**Consultation Response from KC,
Lead Local Flood Authority****2023/90668 Grange Moor Coachworks, Barnsley Road, Grange Moor, Huddersfield, WF4 4DR****Erection of B2/B8 Industrial Unit and associated works****Date Responded: 06/04/2023.****Responding Officer: Martin Stephenson****Responding Ref: 0****Documents reviewed by the LLFA:**

Drawing No: P2753-ACU-XX-DR-A-102-01 Rev No:

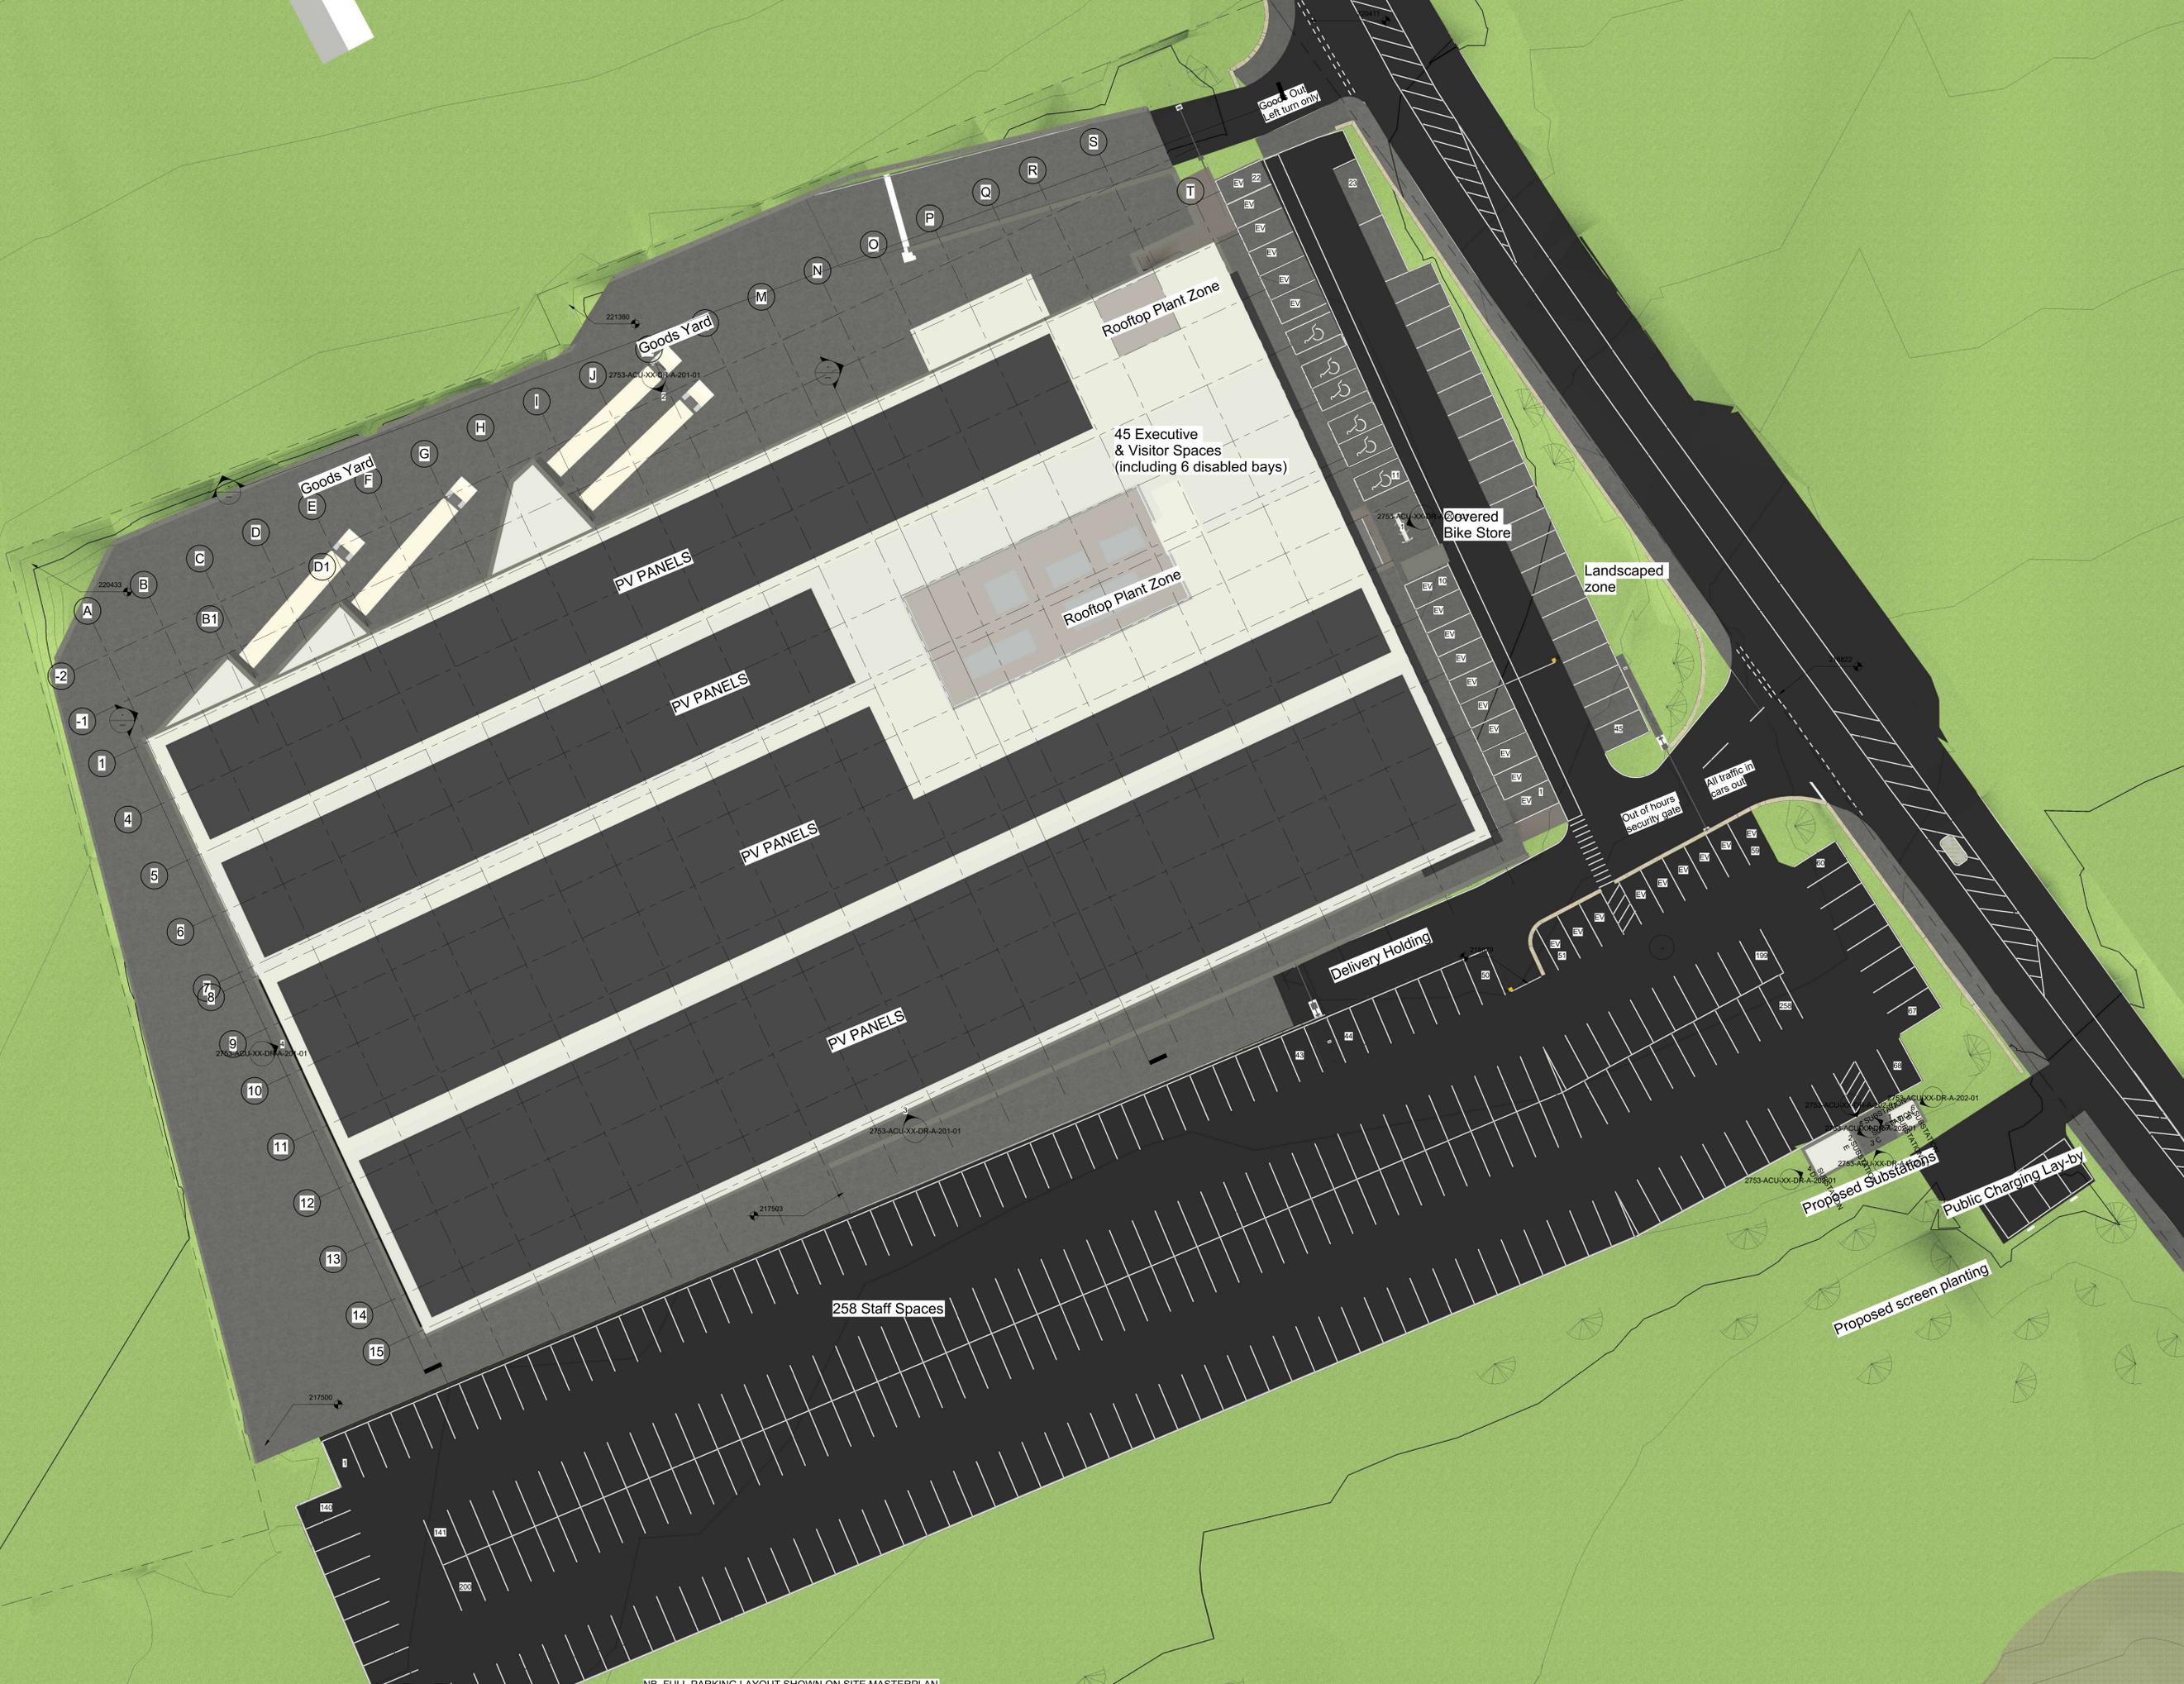
The developer is proposing to discharge surface water run-off at an attenuated rate to an existing pond in the south-east corner of the site via a balancing pond – the LLFA confirms that this is acceptable. However, the developer will be required to prove that this pond drains into the 225mm dia Highway Drain in Barnsley Road (e.g. CCTV survey) and this proof submitted to the LLFA.

As stated in the FRA, the flow control device should be rated at the equivalent Greenfield Run-off Rate and hydraulic calculations to confirm the proposed discharge rate and that sufficient attenuation storage is provided to contain the critical 1 in 100 year (plus Climate Change) rainfall event without flooding of existing or proposed properties or off-site.
